October 19, 2022

RE: Panda Express – S8-22-D8582  
10126 Coors Blvd. NW  
Albuquerque, NM 87114  
RE: DRB Planning Review – 4<sup>th</sup> Resubmittal  
DRB Project Number: 2022-006547  
App. Number: SI-2022-00216  
Delta 4 response

- Heights Venture is providing a response to your comments in the statement below. Our responses are in **RED**.
- TRM engineering response to comments are submitted separately attached to this submittal.

A-100b

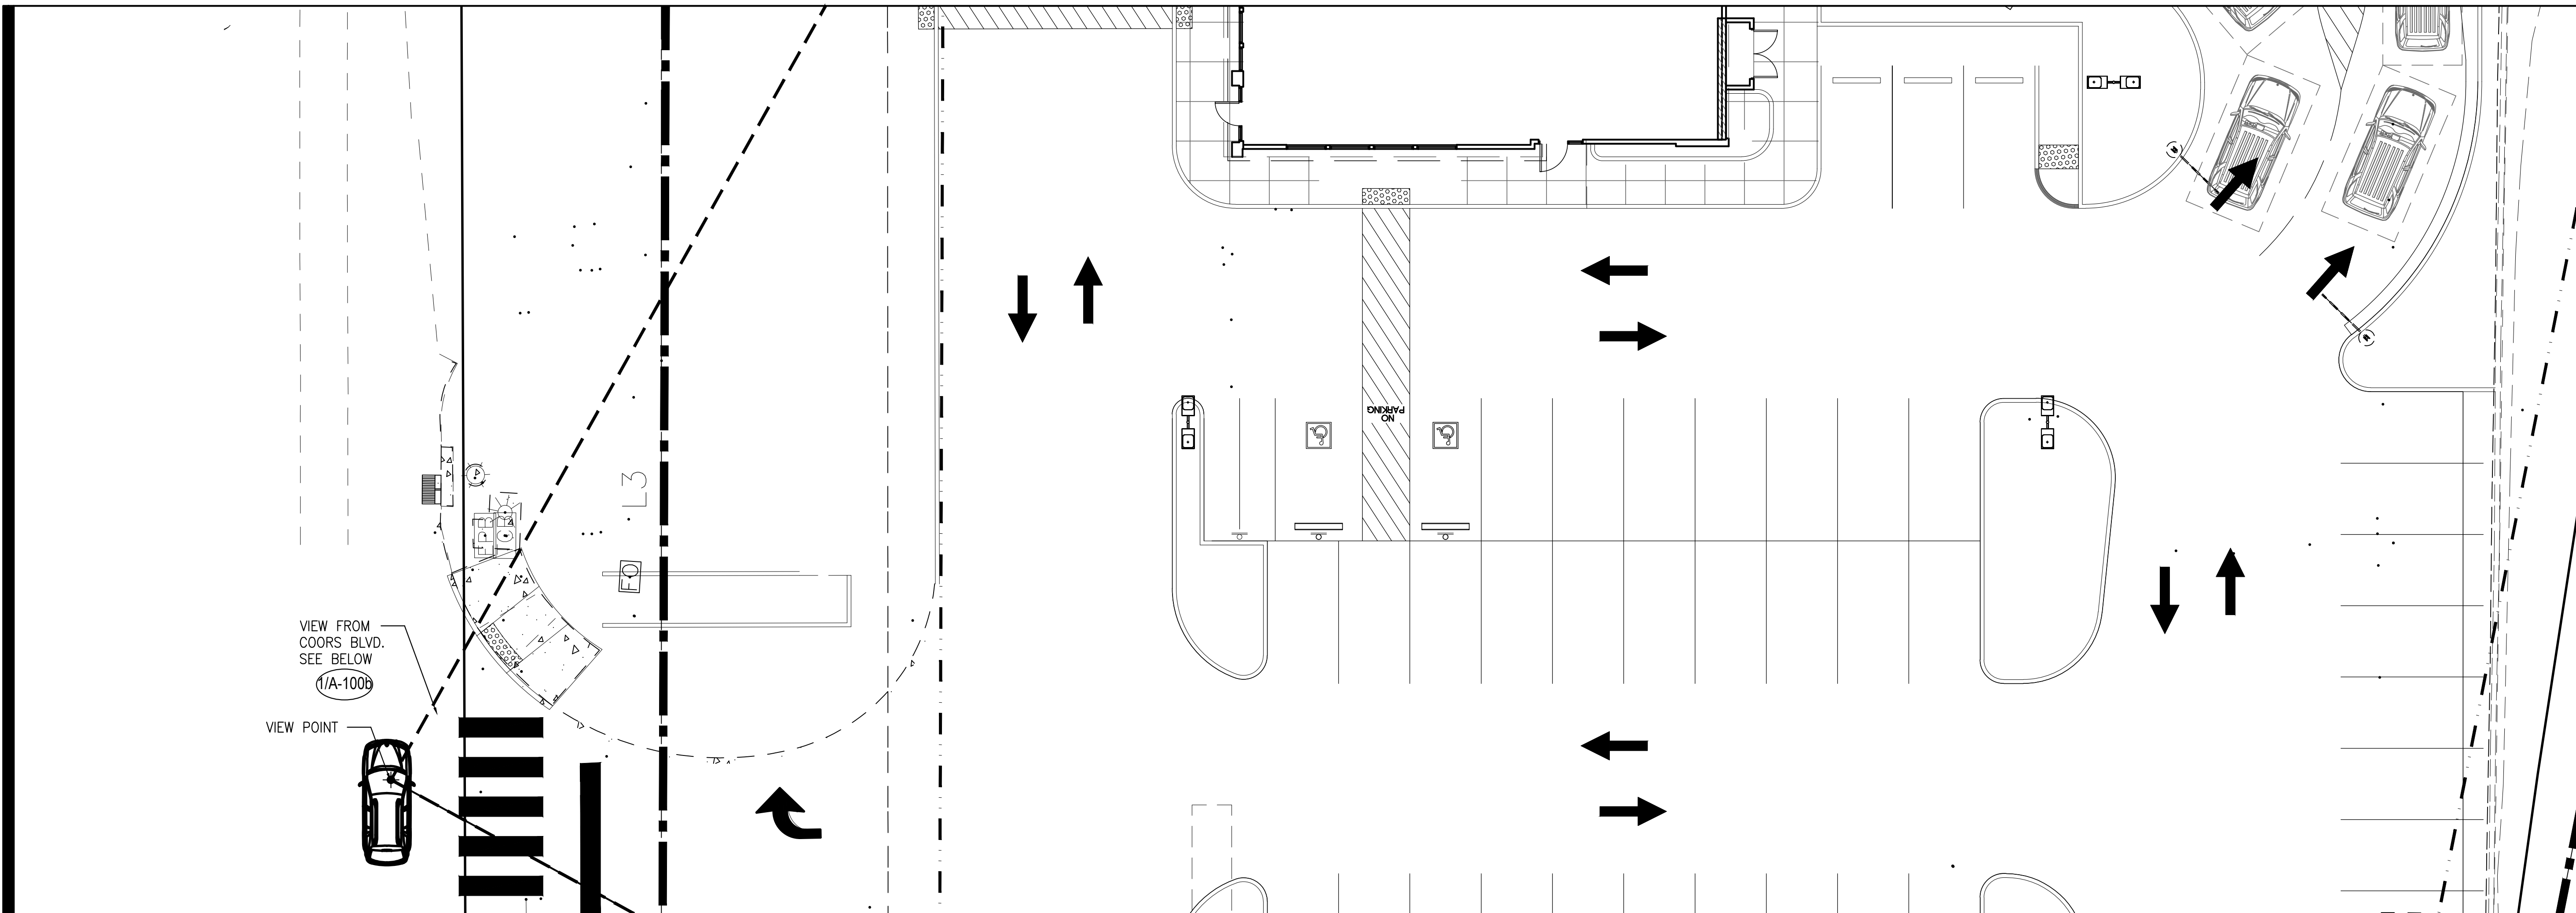
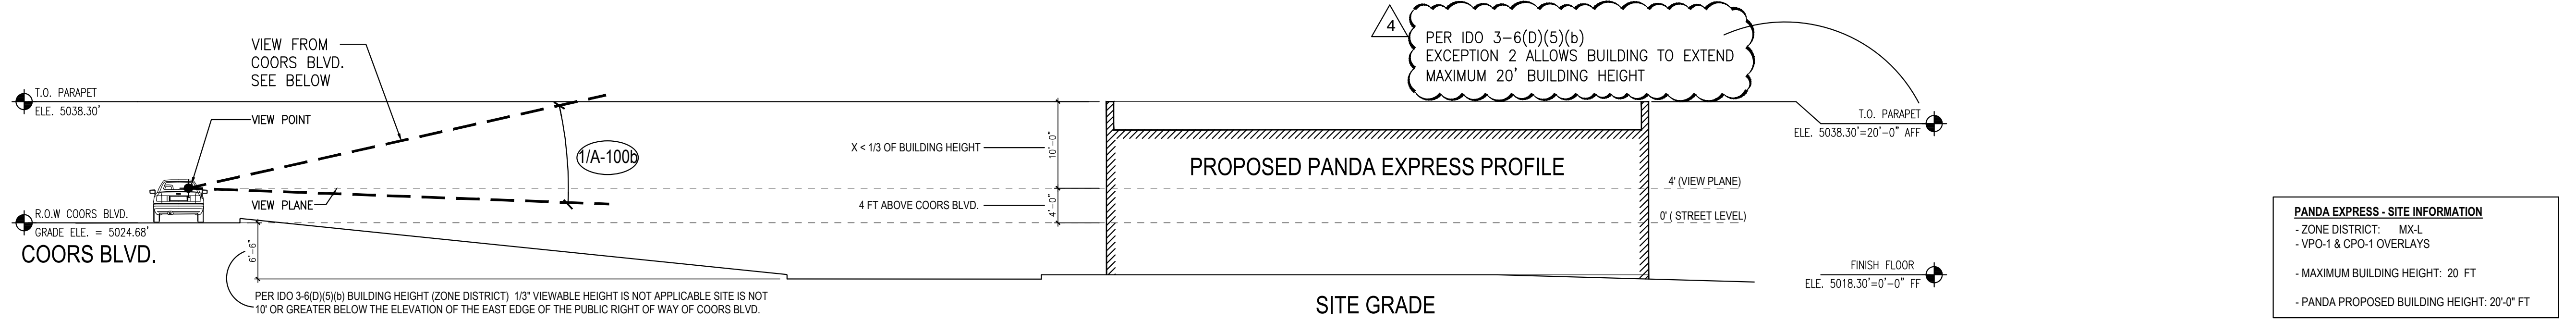
**Response: Please reference to RTM engineering response.**
- Ms. Jolene Wolfley, DRB chair comment to revise the note on detail 2/A-100b, referring to Exception 2 to read “**Exception 2 allows building to maximum 20 feet building height**” above grade of east side of Coors Blvd.

**Response: Please reference to revised sheet A-100b**

A-100

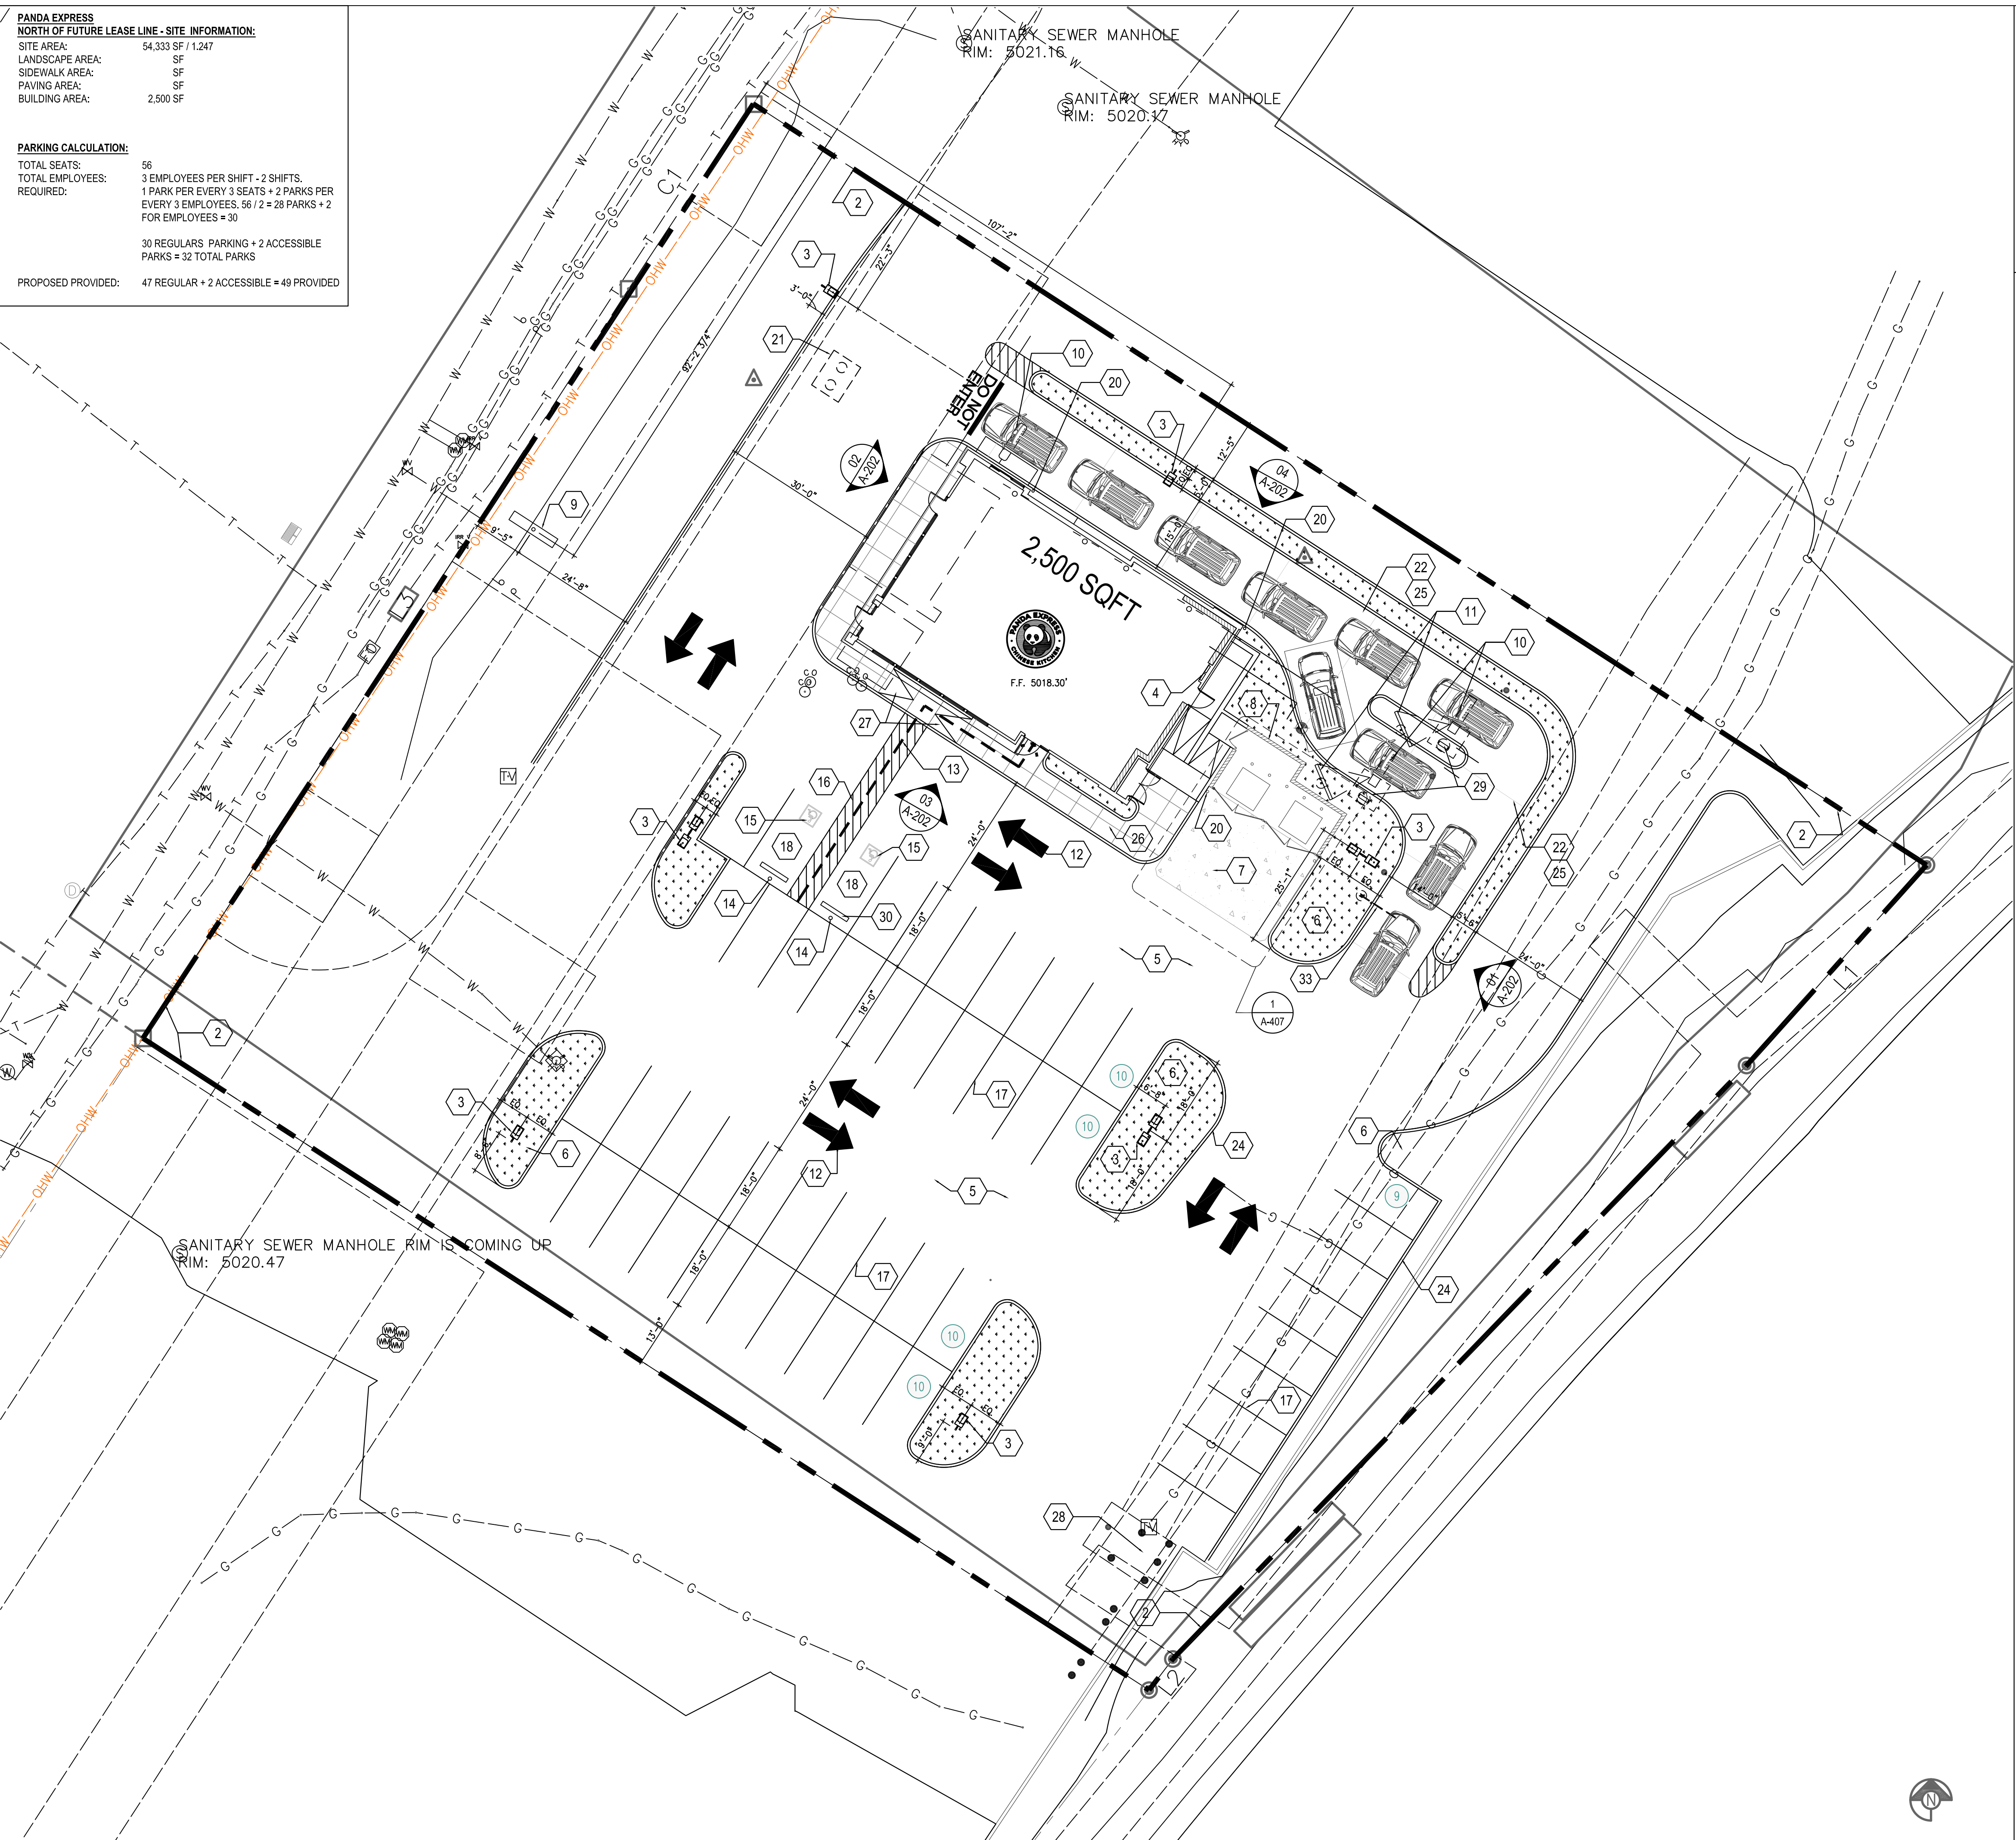
**Response:** *Please reference to RTM engineering response.*
- The clear intersection sight distance triangles shown at the entrance appear to be based on driveway clear sight and not intersection sight distance. Please use intersection on sight distance shown in the new DPM Chapter 7 page 7-114.

**Response:** *Please reference revised site plan, sheet A-100 and Planting plan, sheet L-1. Also, please reference RTM engineering, civil drawing, C03.0.*
